STATEMENT TO SUPPORT THE HOUSEHOLDER PLANNING APPLICATION RESUBMISSION 10 MANOR ROAD, WHALLEY, LANCASHIRE

Following the refusal of the previous application this statement is written to highlight the amendments to the proposal which aim to resolve the reasons for the decision.

SHEET: PROPOSED FLOOR PLAN

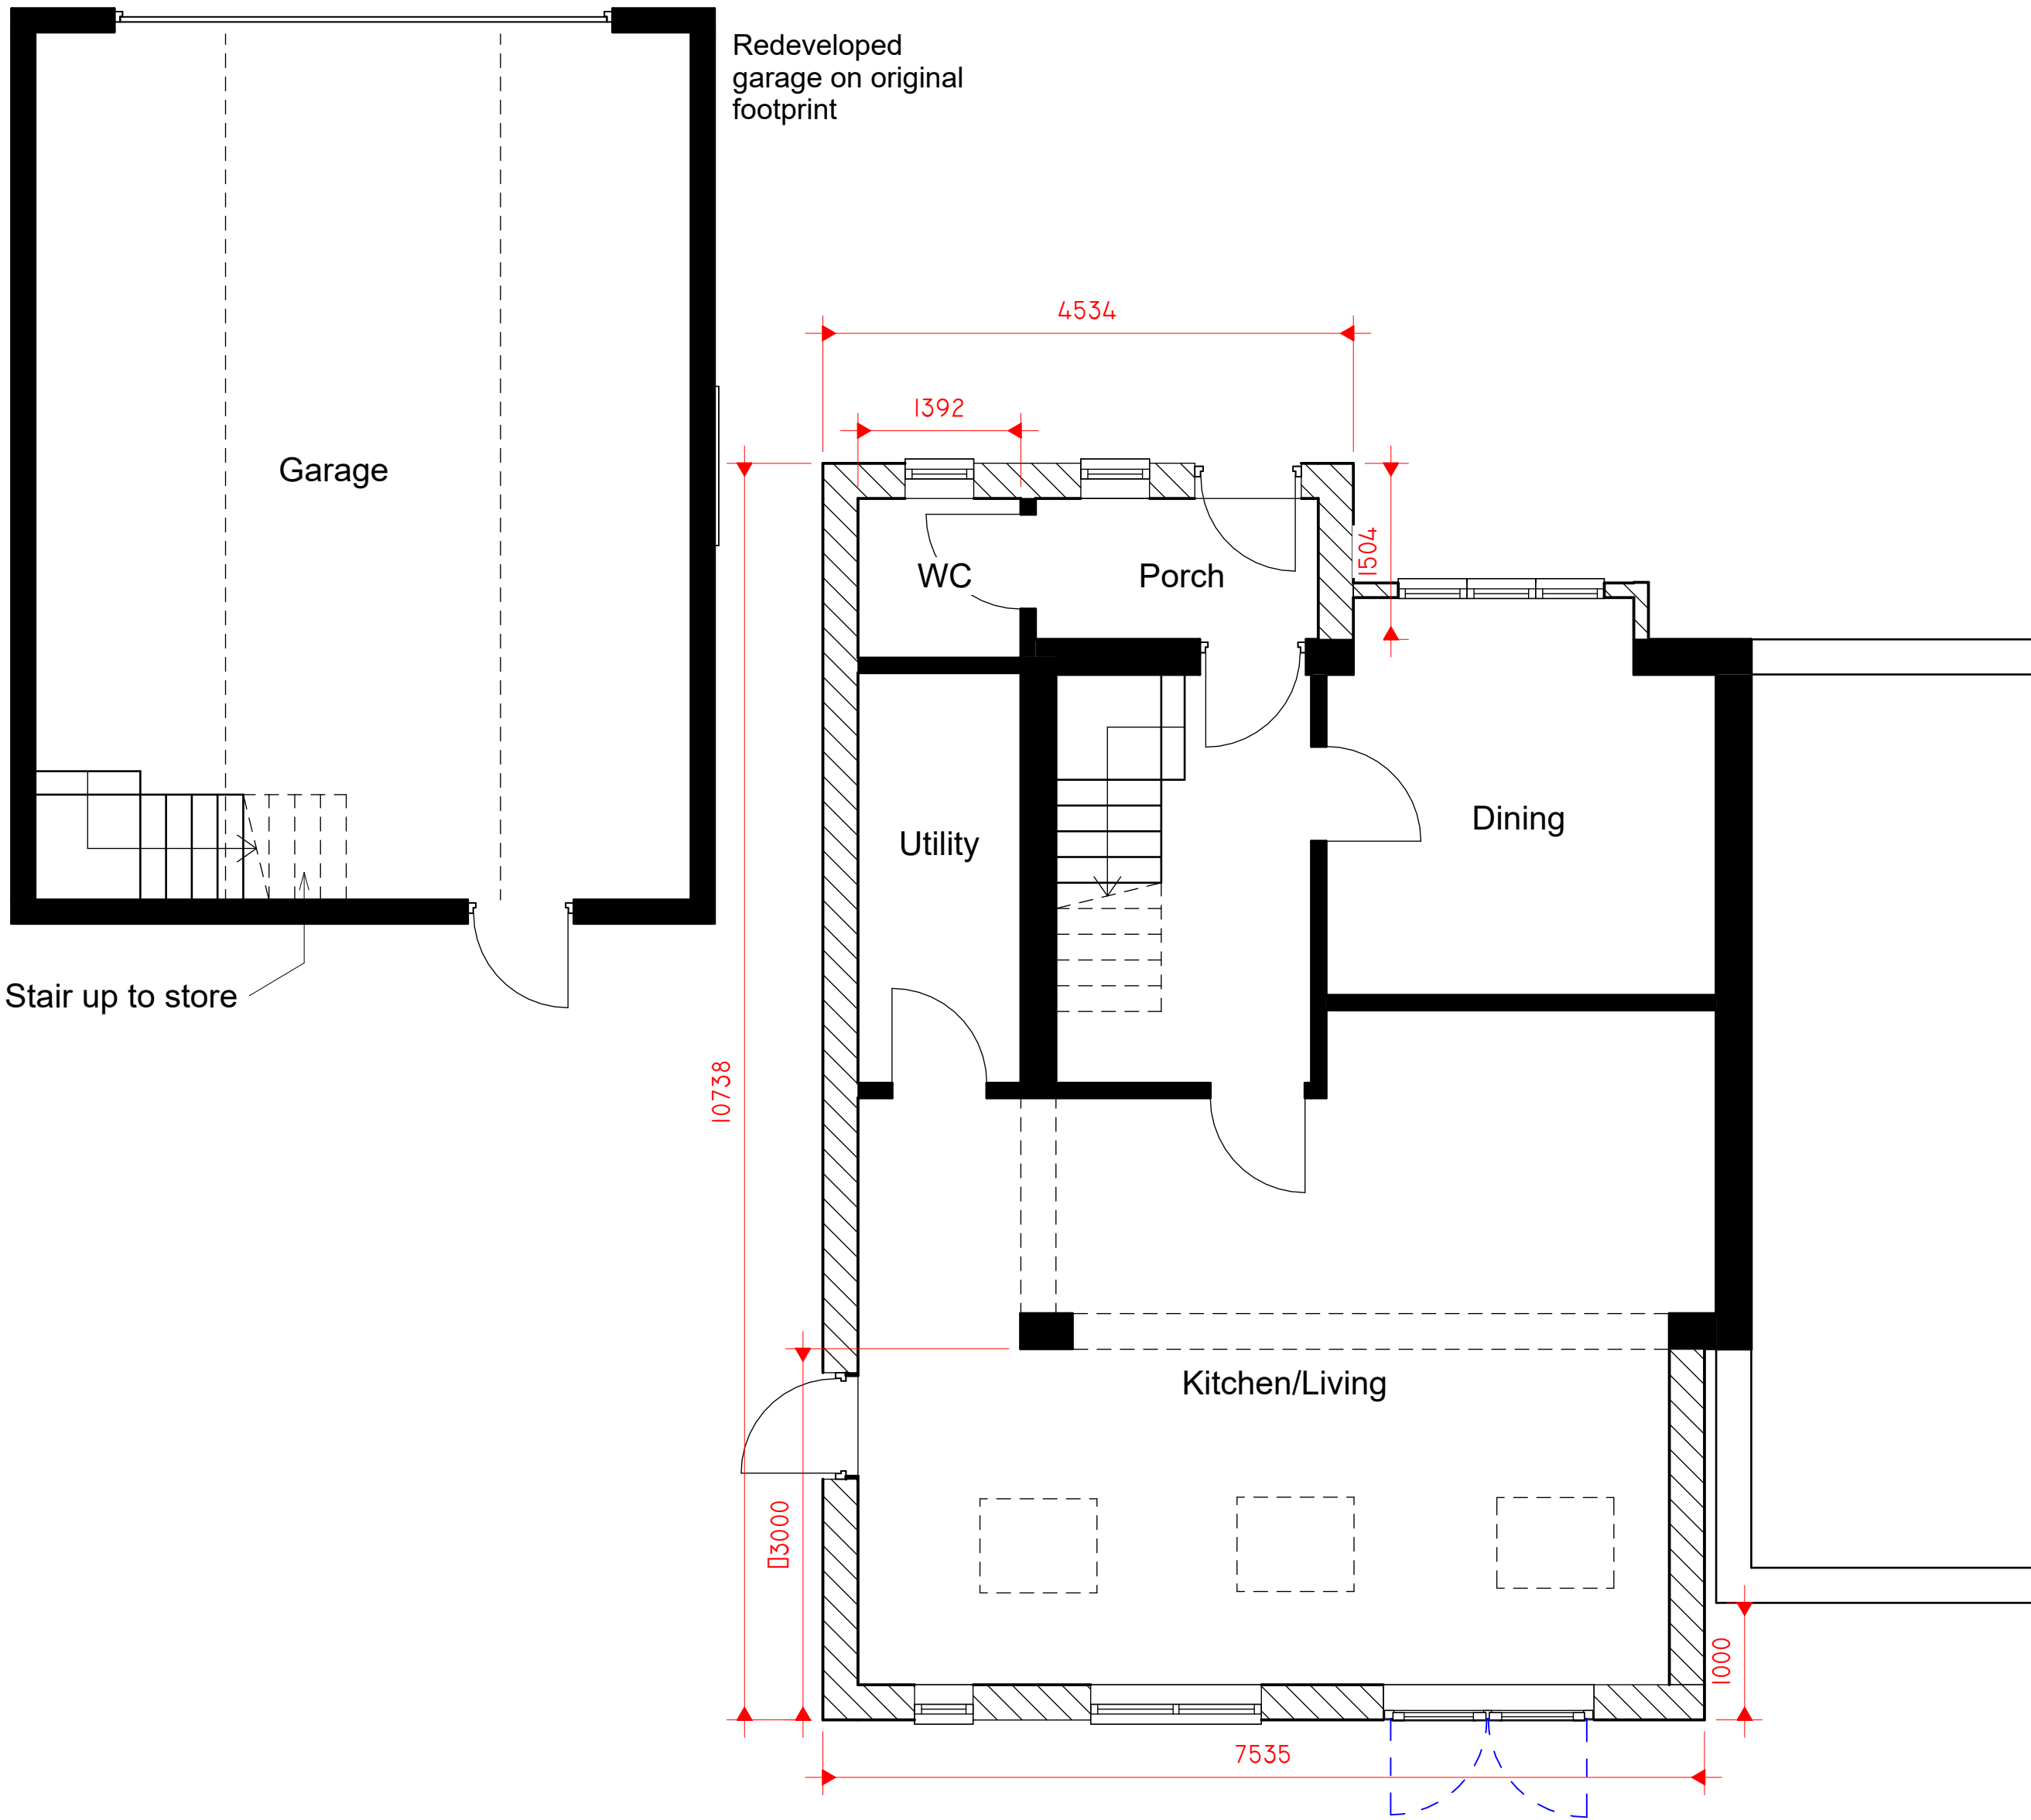
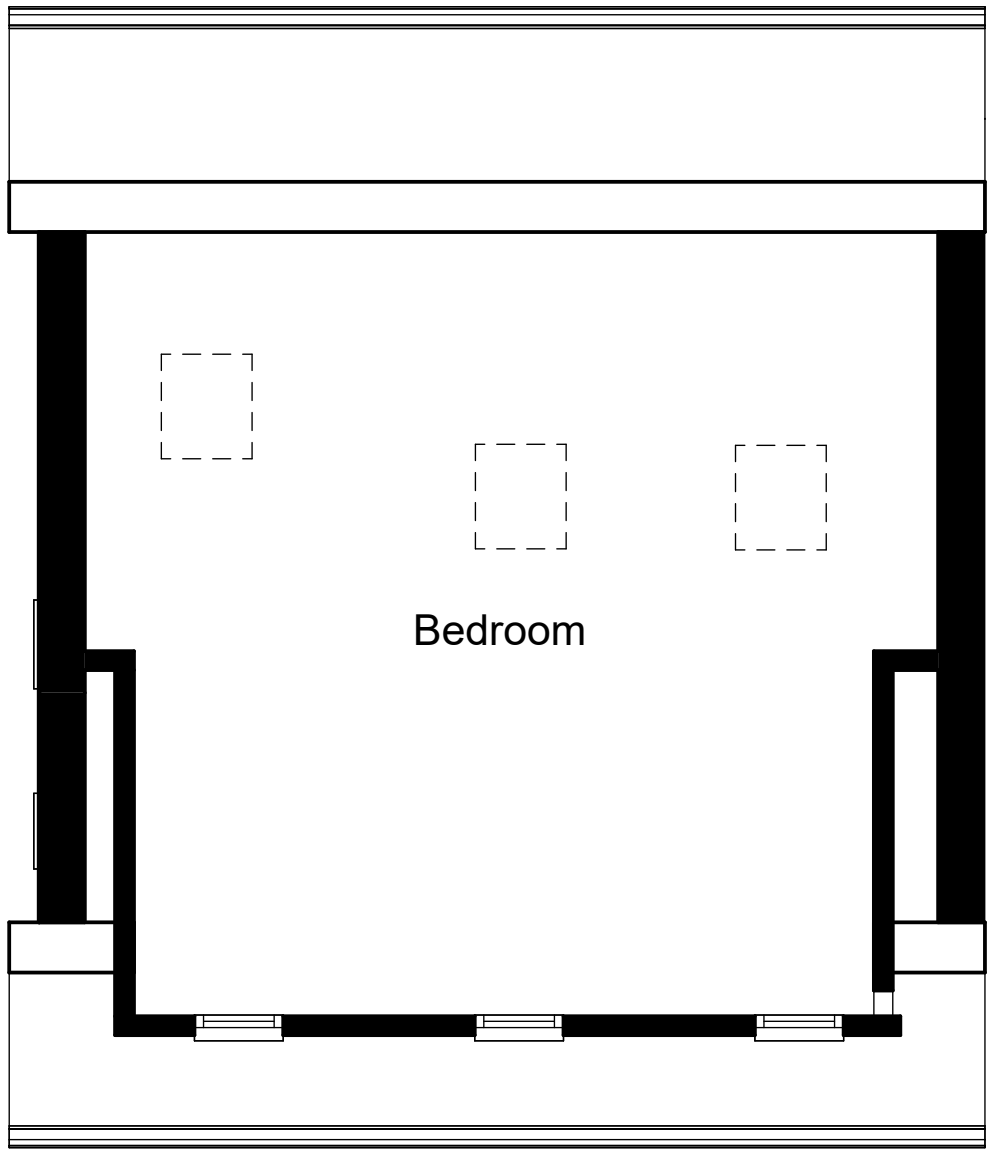
In this instance, the proposal involves the addition of a two storey garage structure which would stand at just over 5 metres in height meaning the roof ridge of the garage would be sited above the eaves of the host property. In addition, the garage's footprint would be offset to the footprint of the main dwelling therefore the proposed garage would be disruptive to the symmetry currently shared between the property and the existing detached garage.

Furthermore, the replacement single storey wrap around extension would incorporate a flat roof design which would be largely at odds with the pitched roof design recently installed on the property. In addition, the incorporation of large glazed openings and composite timber boarding to the front elevation of the proposed extension and the entire first floor level of the property would be entirely at odds with the brick and pebble dashed render elevations and casement style windows installed on neighbouring properties within the immediate locality.

The garage ridge height is 5m and 0.5m below the eaves of the host dwelling. The footprint remains as existing as the garage is to be redeveloped with a loft space. The eaves is raised 0.3m and the existing brick facings are shown as fully rendered. The roof has been re-designed as a gabled arrangement which matches the appearance of the house which has been reconstructed recently from a hipped arrangement to a gable end property.

The wrap around (replacement) extension now incorporates a mono pitch (hipped) roof design. The walls are fully rendered with a brick plinth and the glazing proportions amended.
